From: [Dan Young](#)
To: [Zach Torrance-Smith](#)
Subject: RE: AU-26-00007 Hill - Notice of Application
Date: Friday, May 22, 2026 8:27:36 AM

Cc: Jamey Ayling <jamey.ayling@co.kittitas.wa.us>; Ellie Myers <ellie.myers@co.kittitas.wa.us>;
Bradley Gasawski <bradley.gasawski@co.kittitas.wa.us>
Subject: AU-26-00007 Hill - Notice of Application

CDS is requesting comments on the following Accessory Dwelling Unit application: AU-26-00007 Hill.

SITE PLAN  
 SCALE 1" = 50'-0"  
 0' 50' 100' 150'

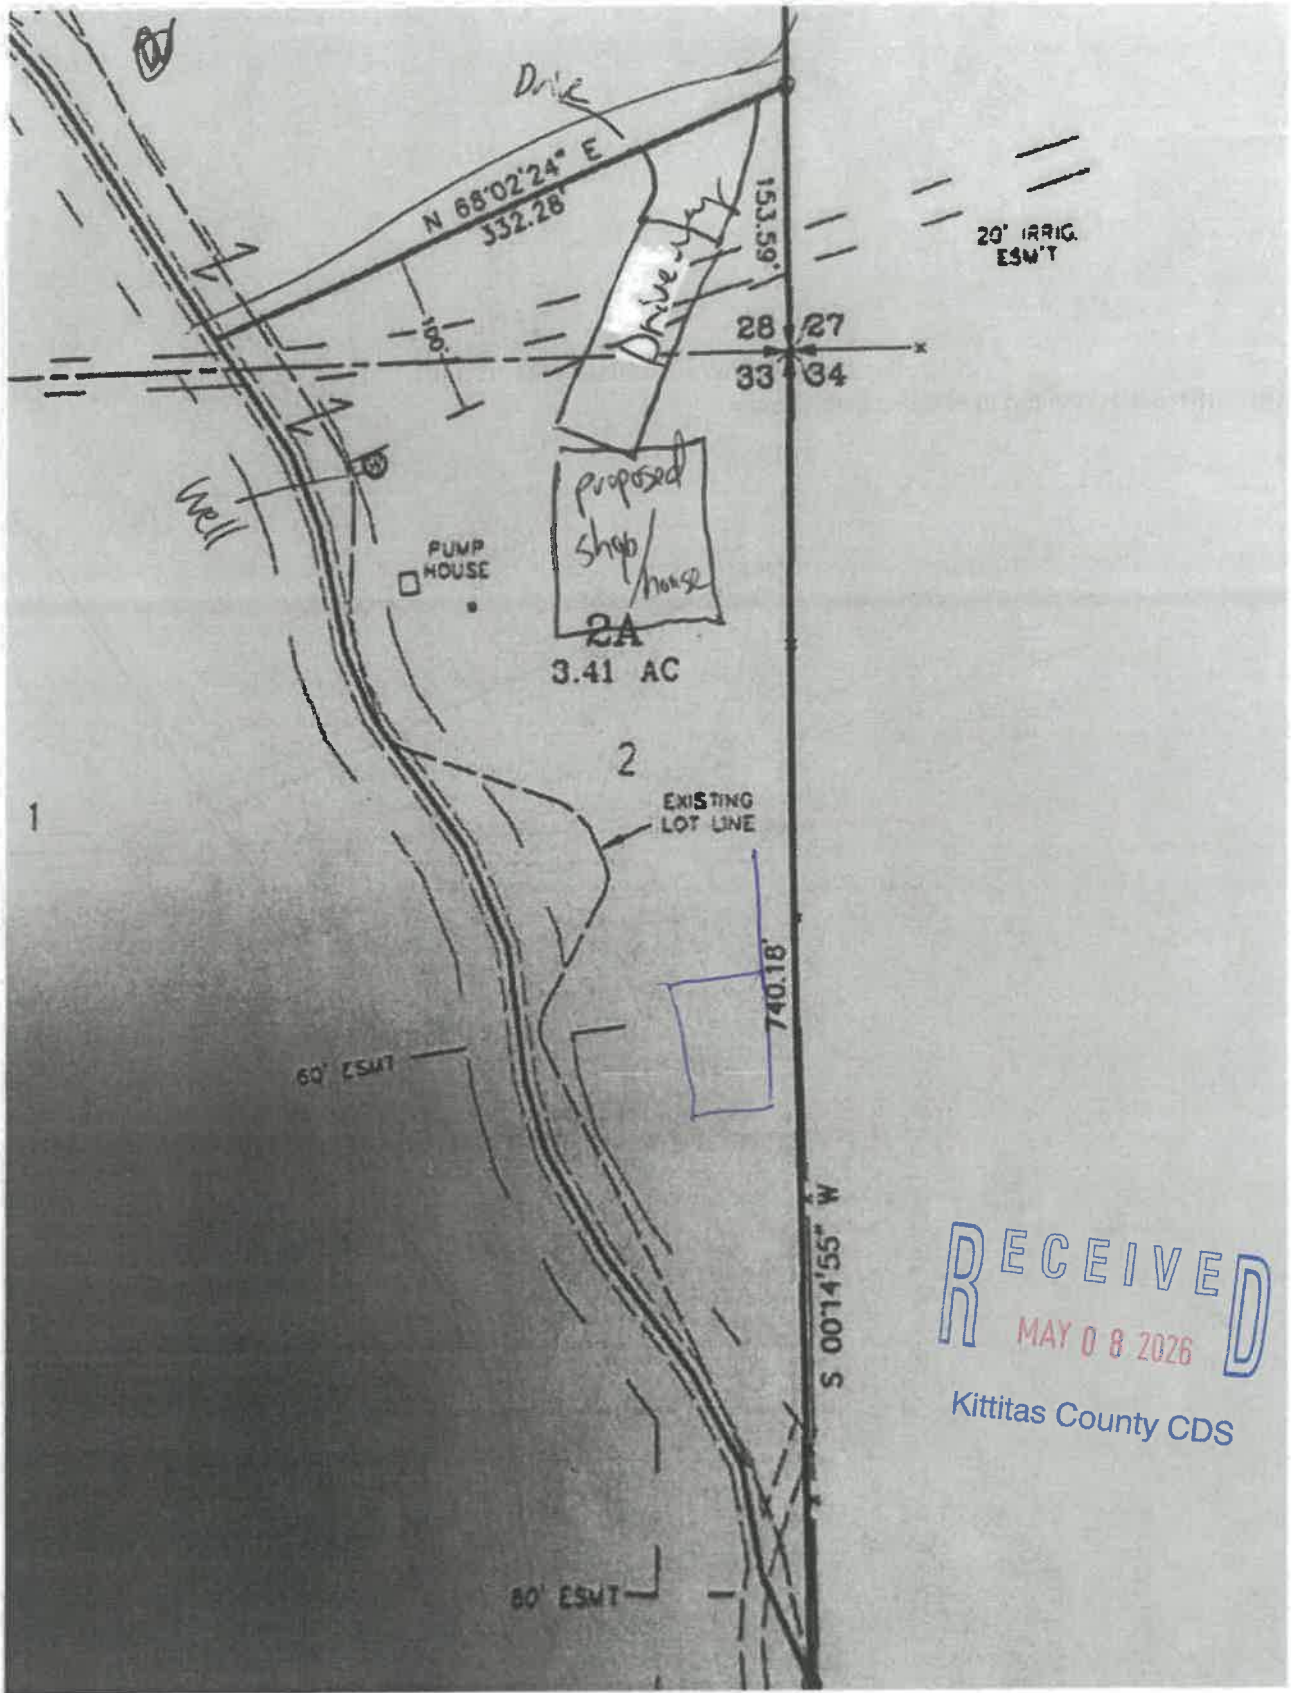
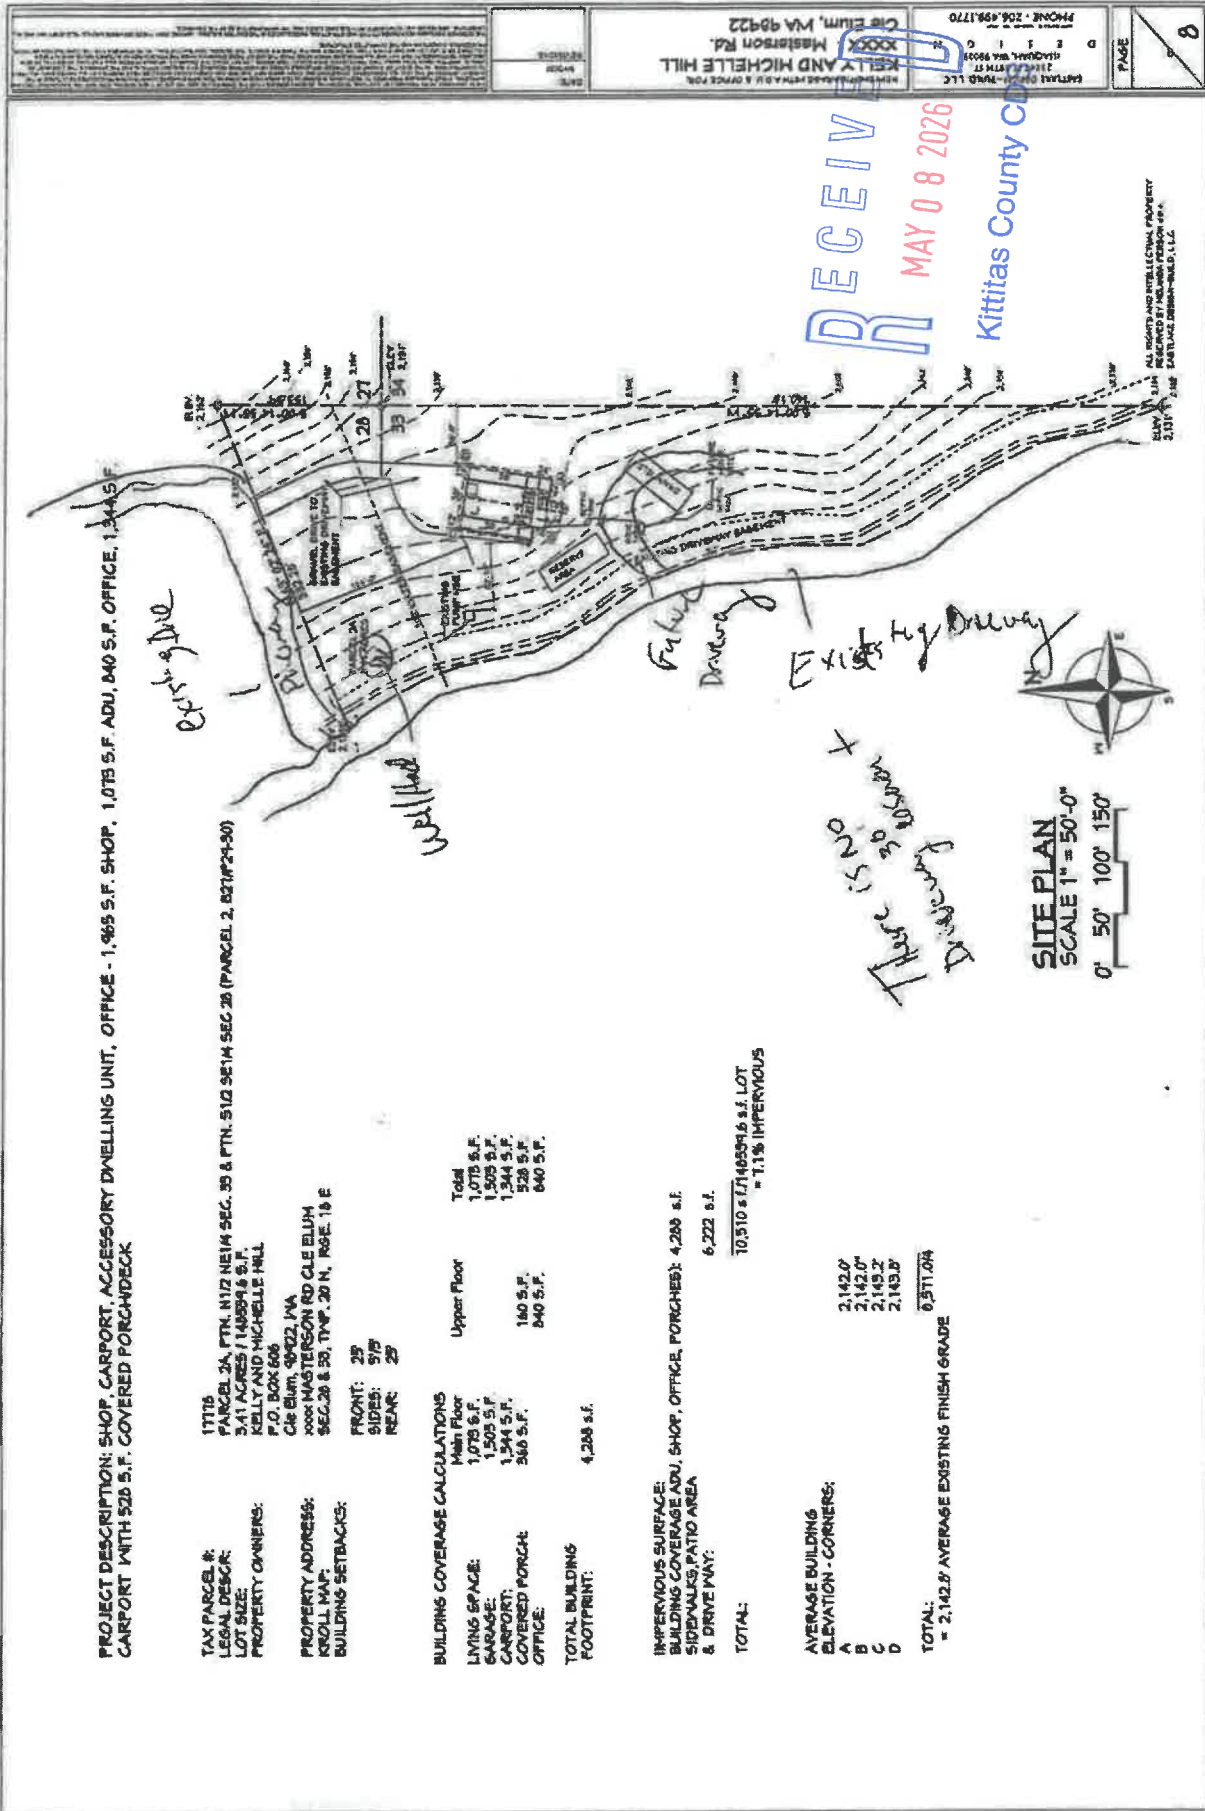
Driveway must meet county code for length and width per KCC 12.04.07.060 #12 and meet International Fire Code Appendix D.
